This is to certify that Savi Realty LLC/Great Falls Const.  
has permission to Install an exterior egress Stair System

Located At 193 MIDDLE PERMIT #2011-01-208

Akan - Exterior Egress Stair  
on the existing 193 Middle St. building.

PROJECT NAME: AKARI EGRESS STAND

1 SECTION
1/8" = 1'-0"

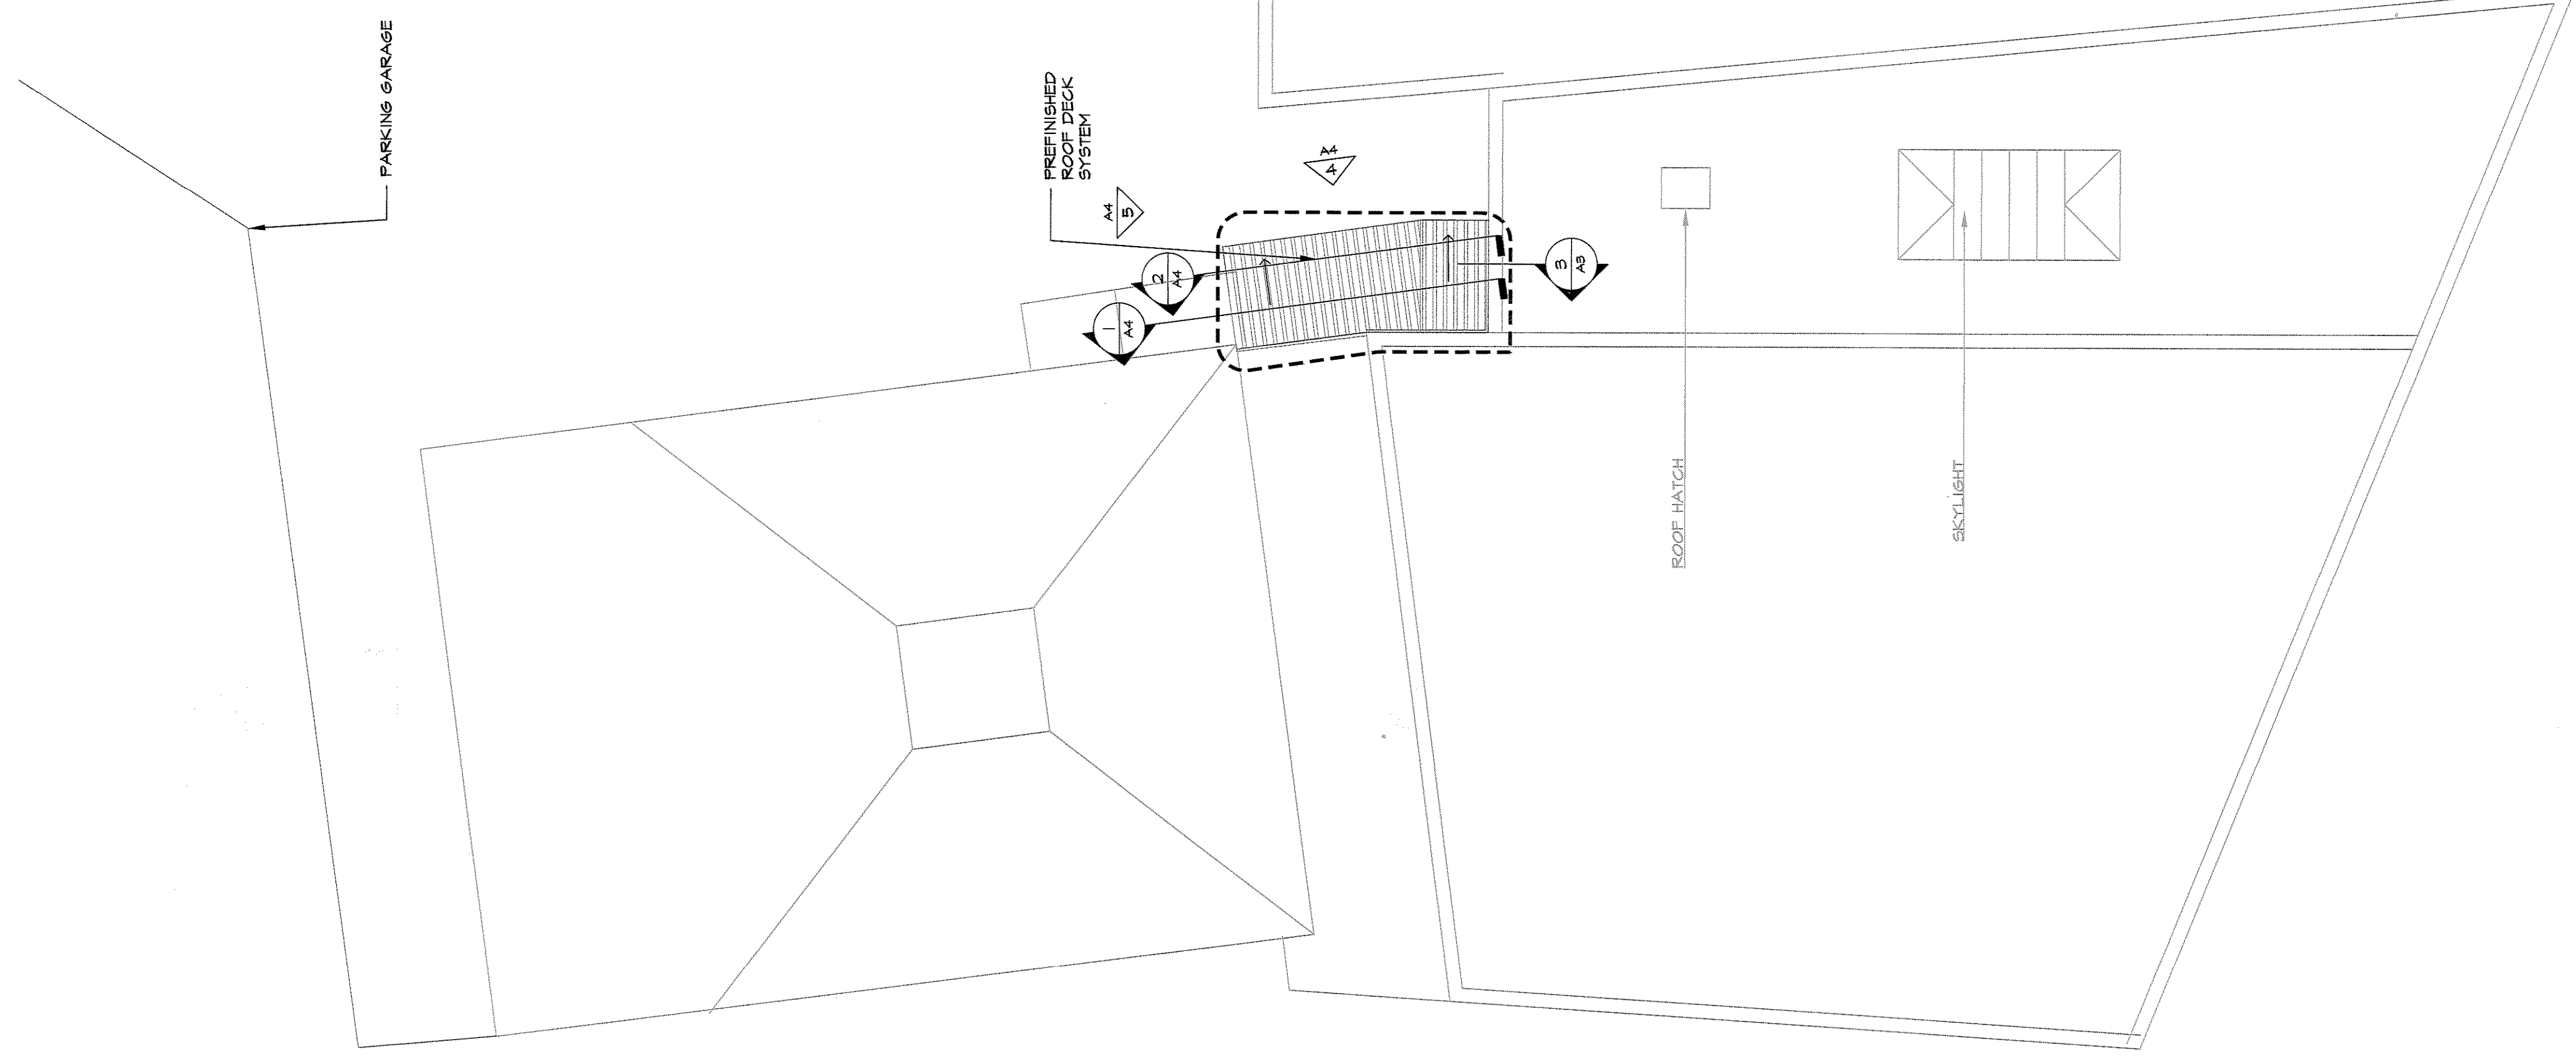
Thanks for getting back to me so quickly today. It sounds like the best solution here is to request a waiver for the tread depth to be 10" rather than 11". Please consider this and let me know at your earliest convenience what else you will need from me.

Please reference section 2/A4 to see how tight the stair already comes to the existing stairway roof. This section also shows the proper depiction of the stair re: tread-riser continuum. I've also attached a pair of details that are typical (not yet revised to specifically coordinate with the project), but show the design intent there. Please also reference 2/S1.2 for the relationship of the column at NW corner of the stair to the adjacent historic structure. The stair structure cannot be moved East to clear this, as the required 10' clearance to the neighboring (unsprinklered) building to the East is within an inch +/- tolerance as shown.

The City of Portland will grant the waiver provided that SFMO approves. The solid risers will still be required.
